## POST EPC MEMORANDUM

RE: PR-2022-007851, SI-2022-02075-Buddhist Temple, Site Plan – EPC Major Amendment

**Project # PR-2022-007851**

SI-2022-02075 - Site Plan- Major Amendment

A1.2
XX OF XX SHEET

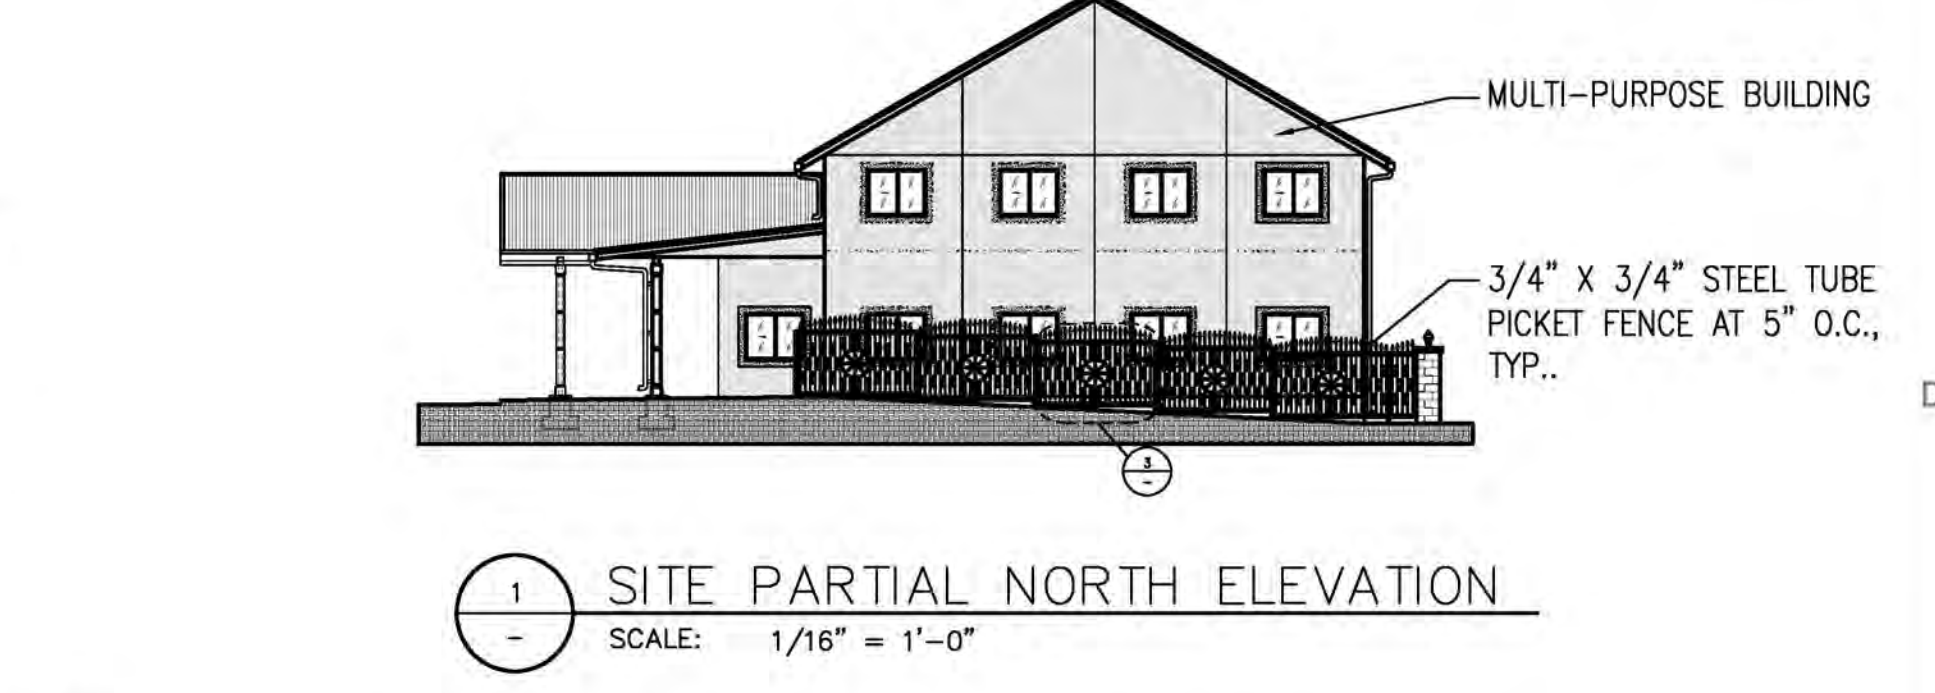
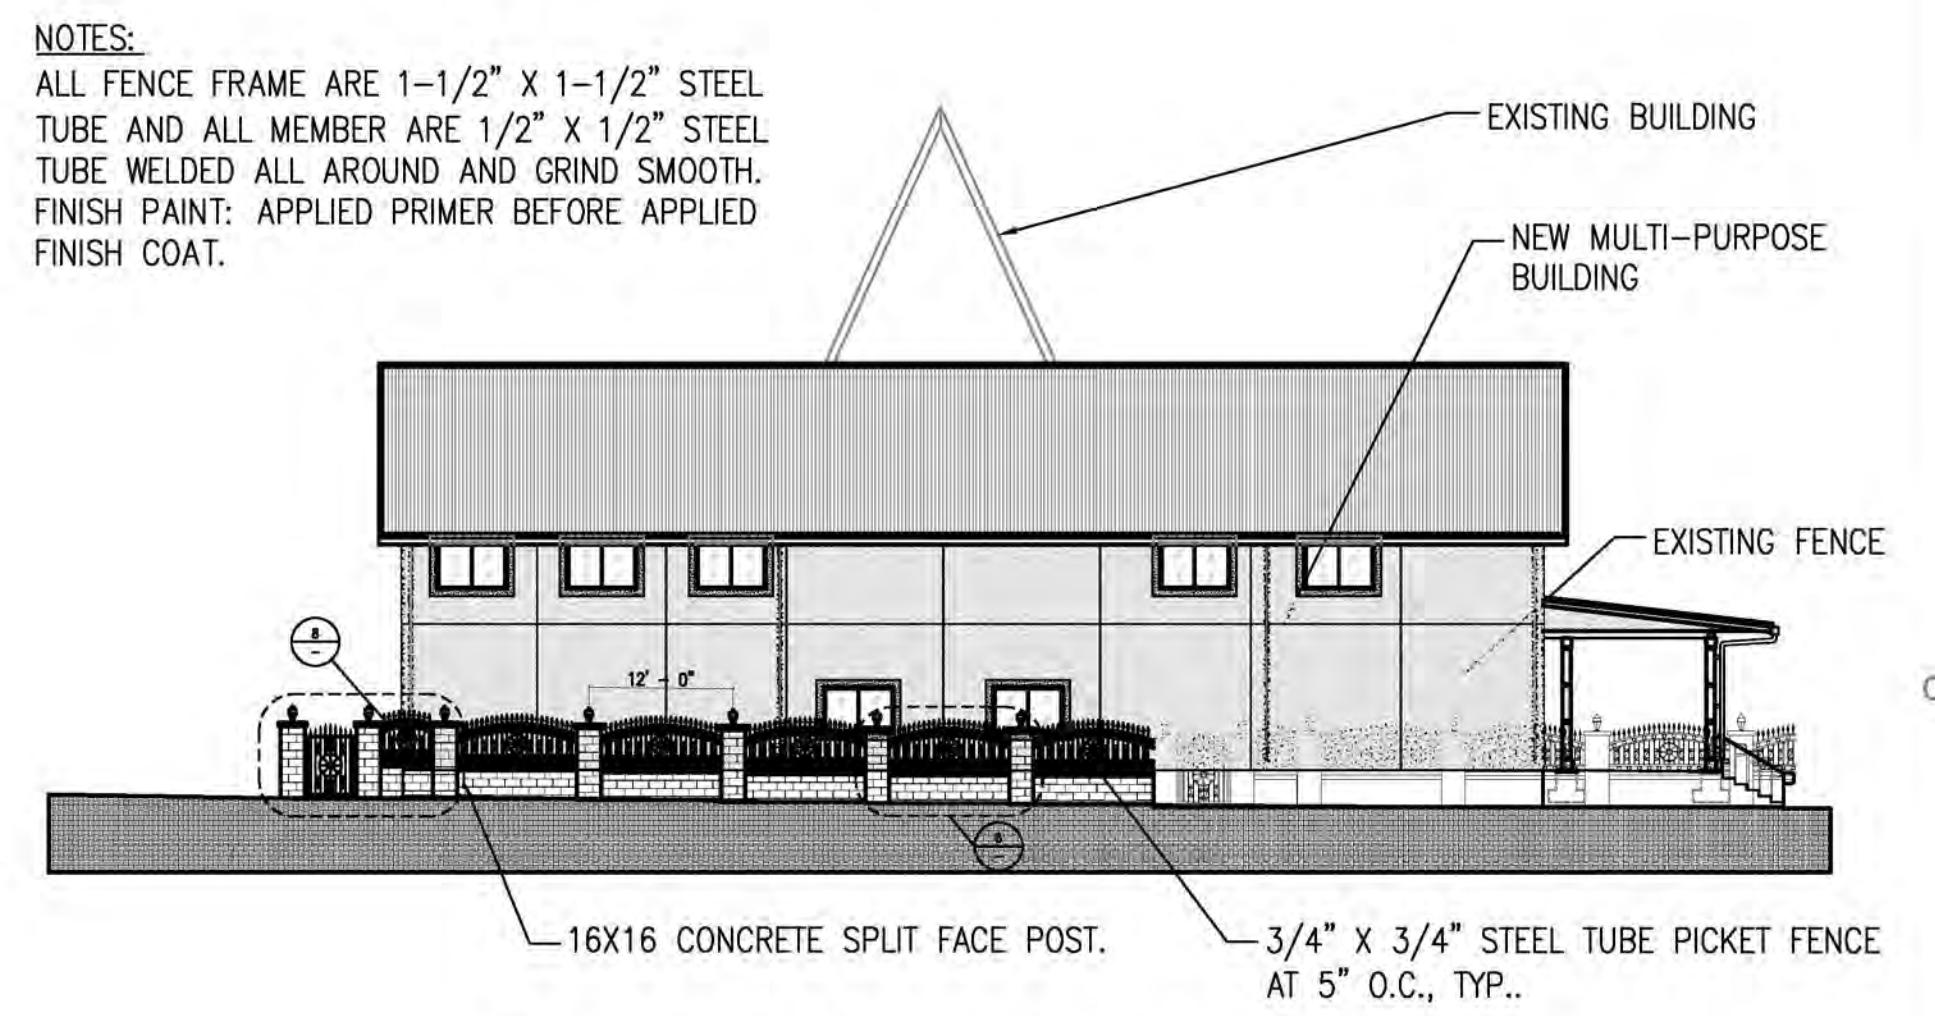
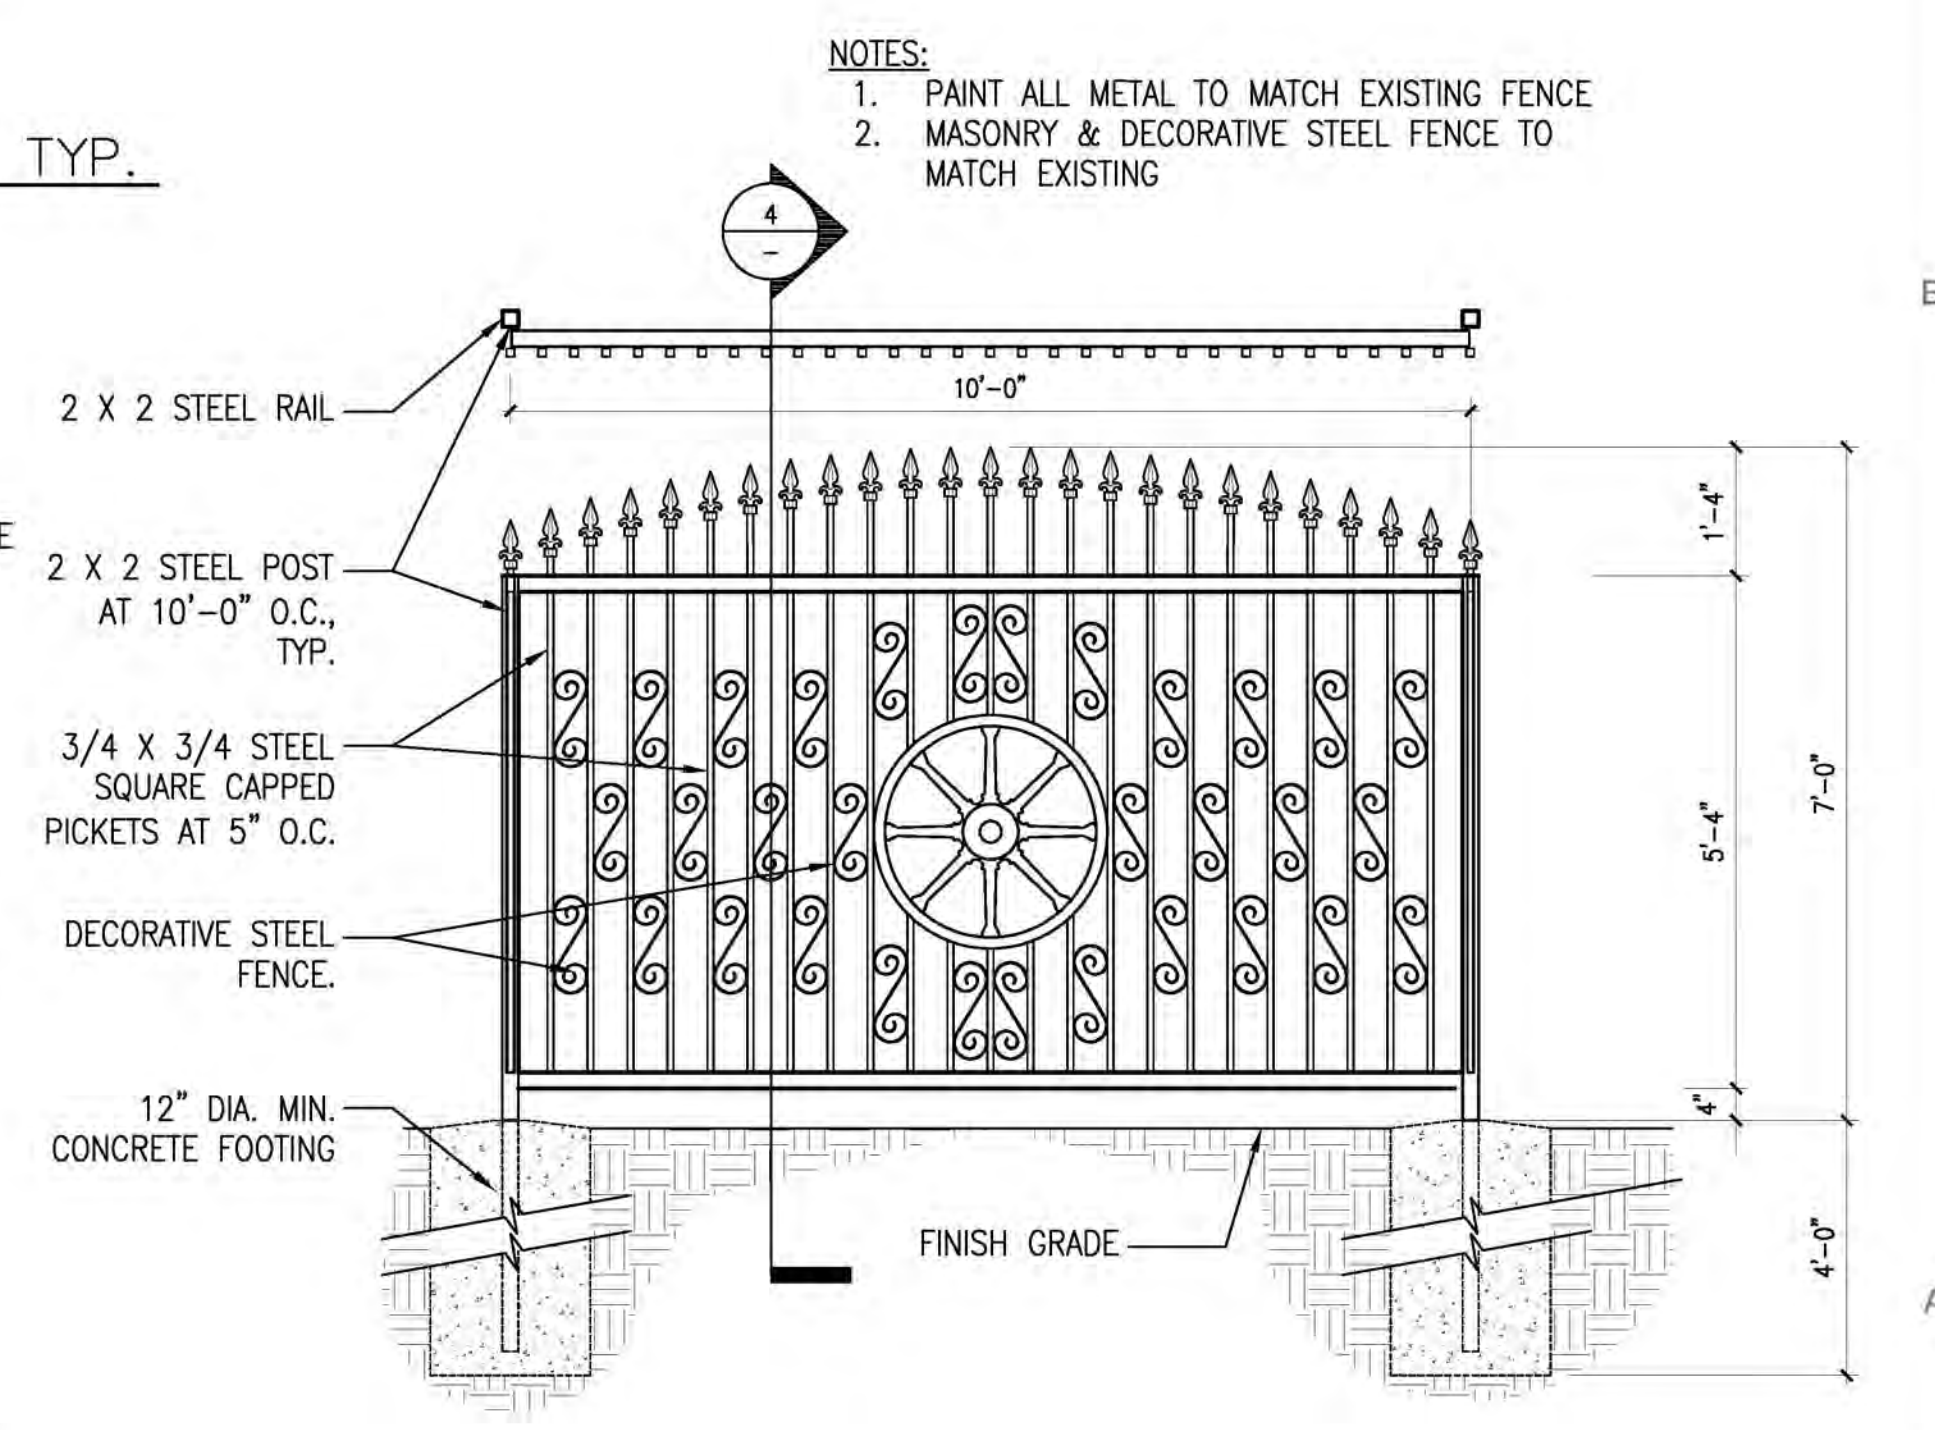
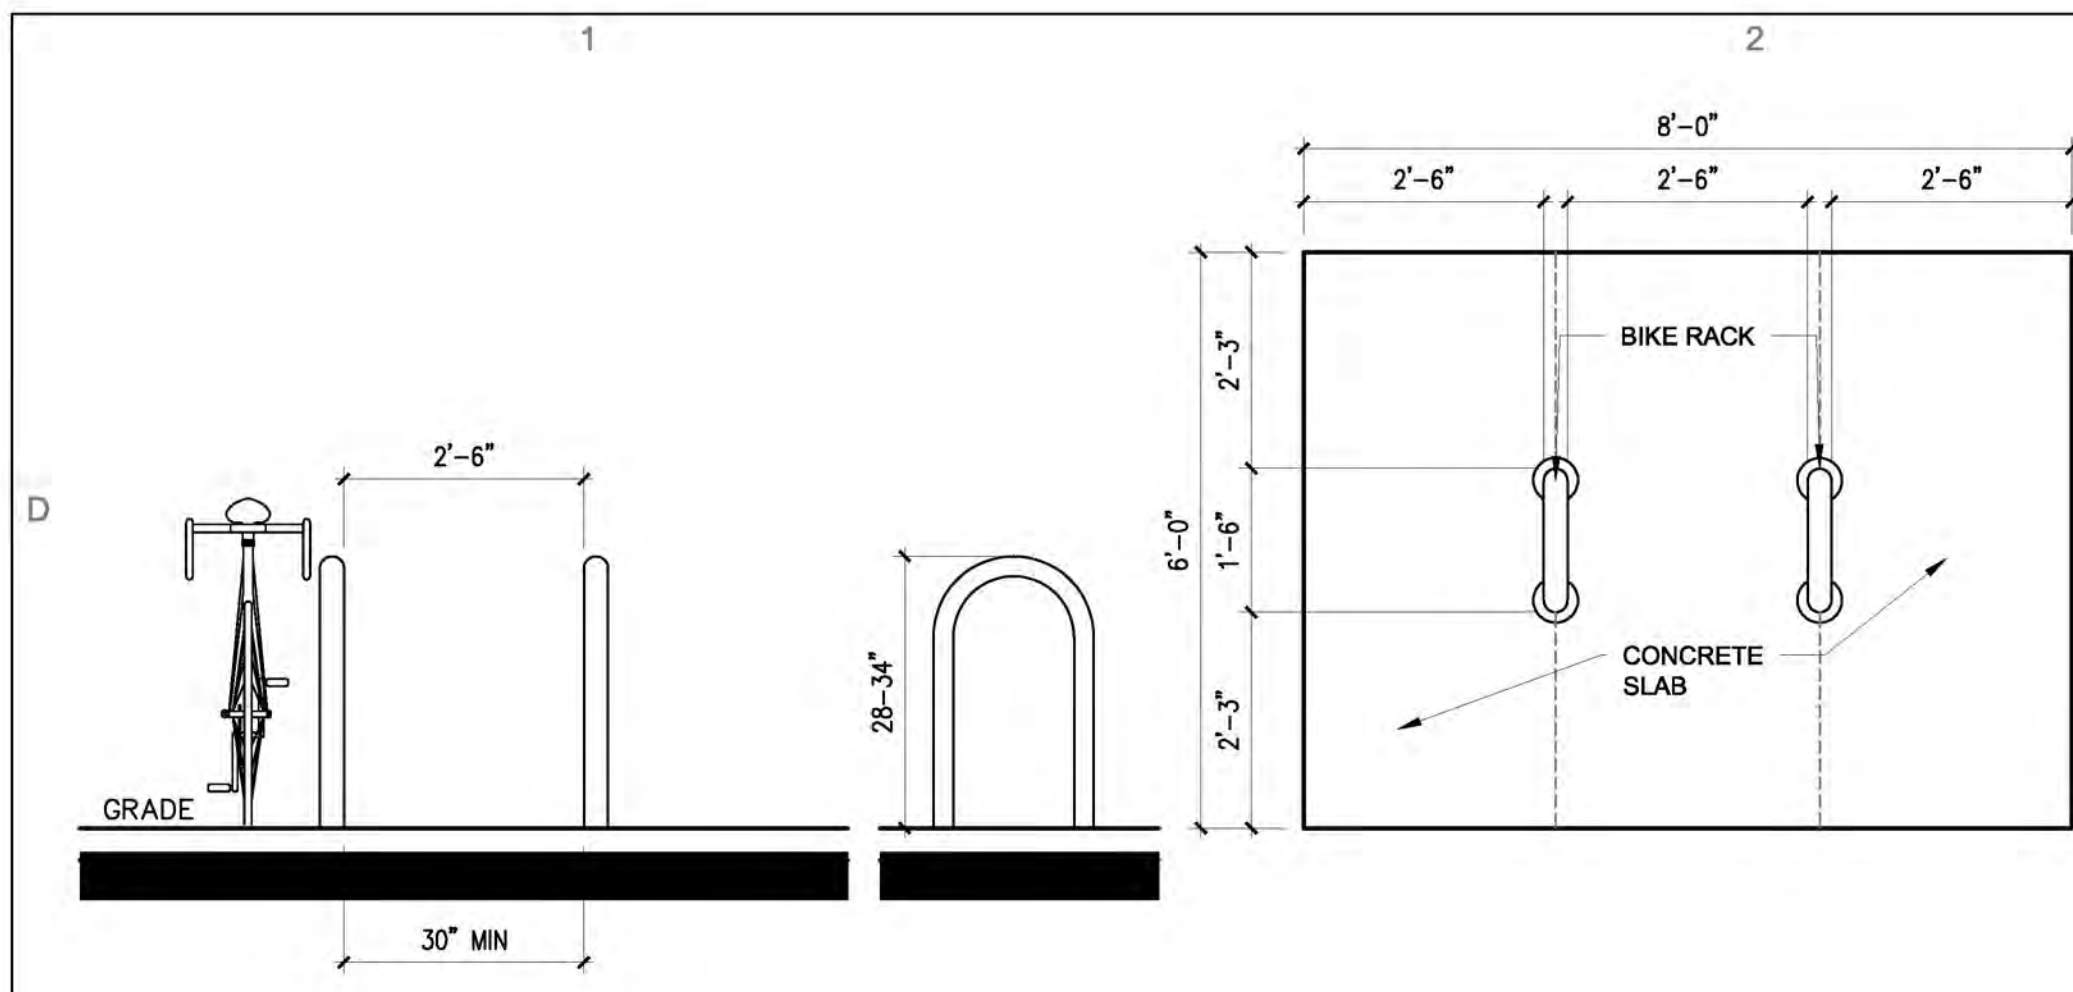
5. **Wall/Fence height** shall be subject to IDO standards unless a variance is obtained.

The IDO reflects within MX-M zoning a wall height on side and front yards of 3'-0" and walls on other locations of the lot to not exceed 8'-0" tall. [Footnote 4. Taller walls may be approved in any mixed-use zone district pursuant to Subsection 14-16-5-7D3C] The new masonry site walls are 2'-8" high 10'-0" long between 2'-0" square by 6'-0" high masonry pilasters at each end of the low wall. Decorative steel picket fence panels are placed between the pilasters. This design replicates the existing site perimeter wall along Zuni and Louisiana Boulevard. In accordance with the IDO a request for variance will be submitted for review and approval. This perimeter site wall/fence design with the pilaster top lighting reflects the recommendations of "Crime Prevention through Environmental Design" (CPTED). The User's will contact APD reviewer Laura Kuehn, NCPS/ICPS regarding the CPTED recommendations and the offer to conduct an on-site security survey after the project is complete.
